Please ask for: Ms Iqraa Malik
Email: iqraa.malik@terraquest.co.uk
Telephone: 0121 234 1390
Our Ref: Y/36/22/HH
Your Ref:
Date: 22nd March 2022

Application for Planning Permission for Works or Extension to a Dwelling

Development: Erection of detached workshop, gym/hobby and greenhouse. (This application affects Character & Appearance of the Main Road/Church Road, Yapton, Conservation Area and a Listed Building.)

Location: Berri Court Main Road Yapton BN18 0ED

Title
SITE PLANS

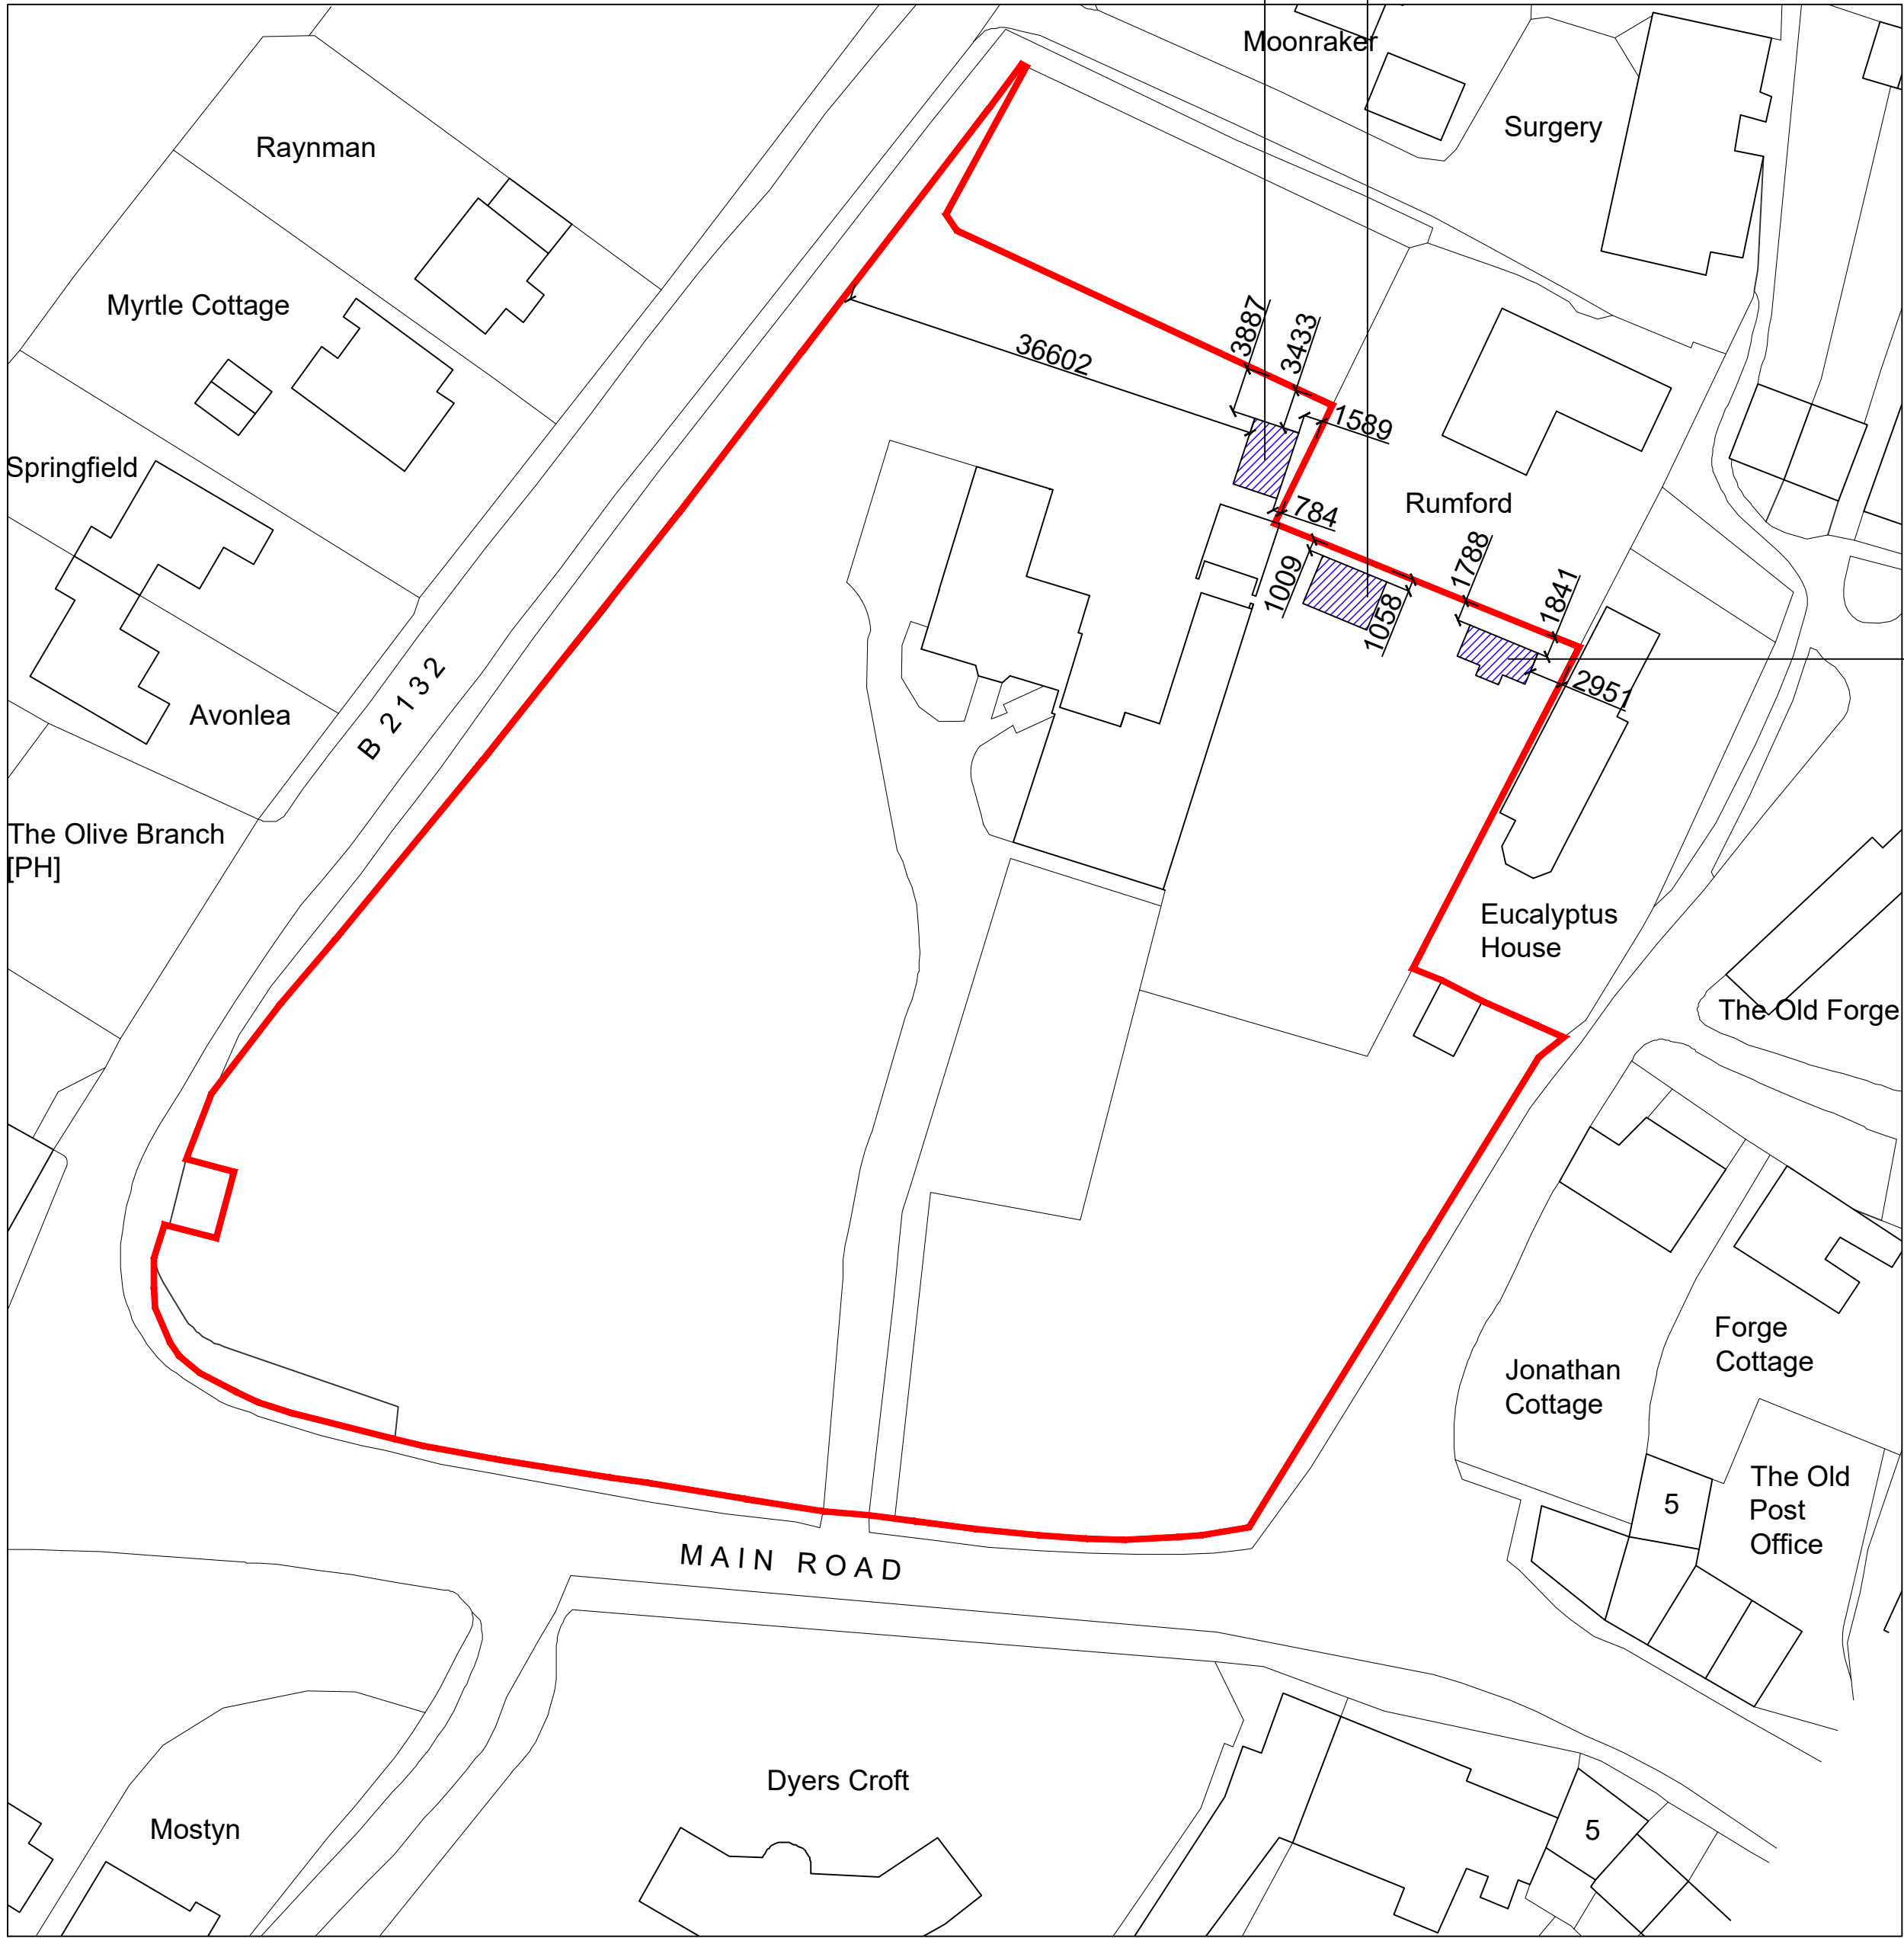
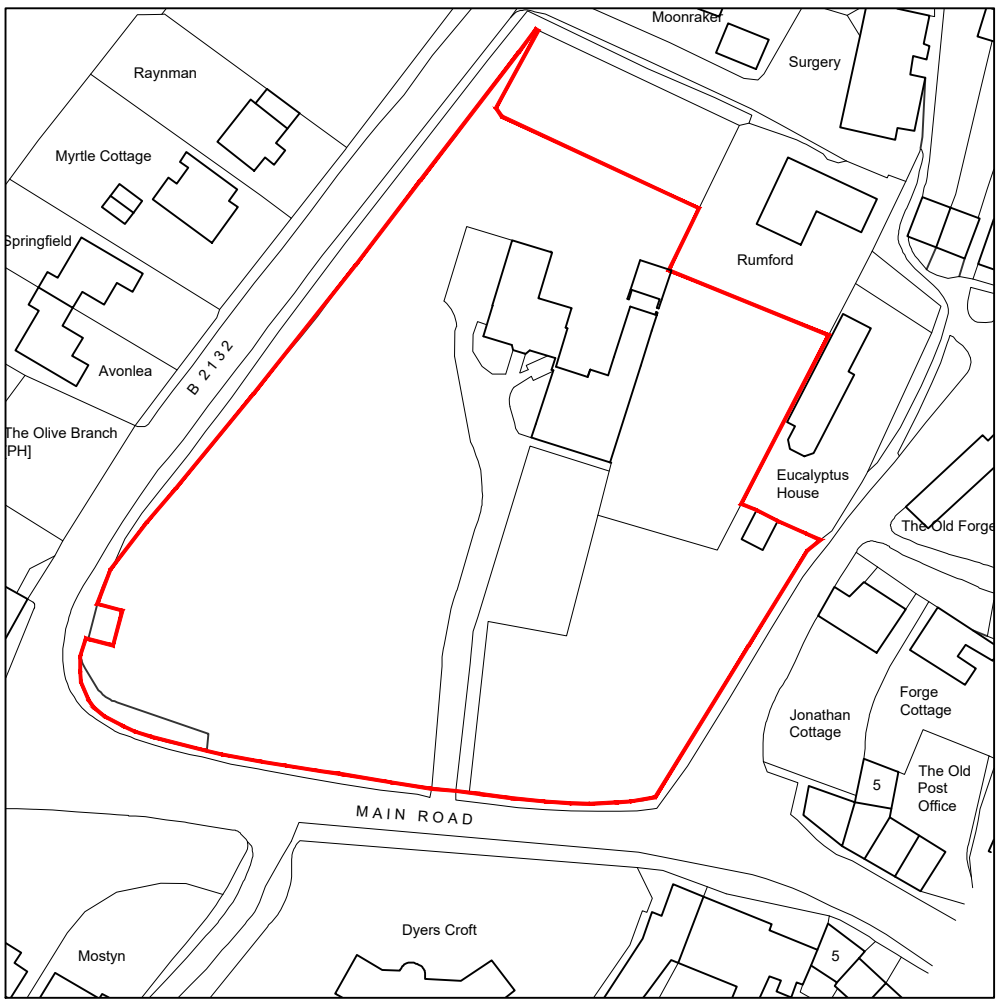
Block Plan

The proposed buildings are not measuring consistently on the proposed block plan with the other plans submitted. Along with this, you are required to have dimensions from the proposed extension(s) to all site boundaries. Please amend.
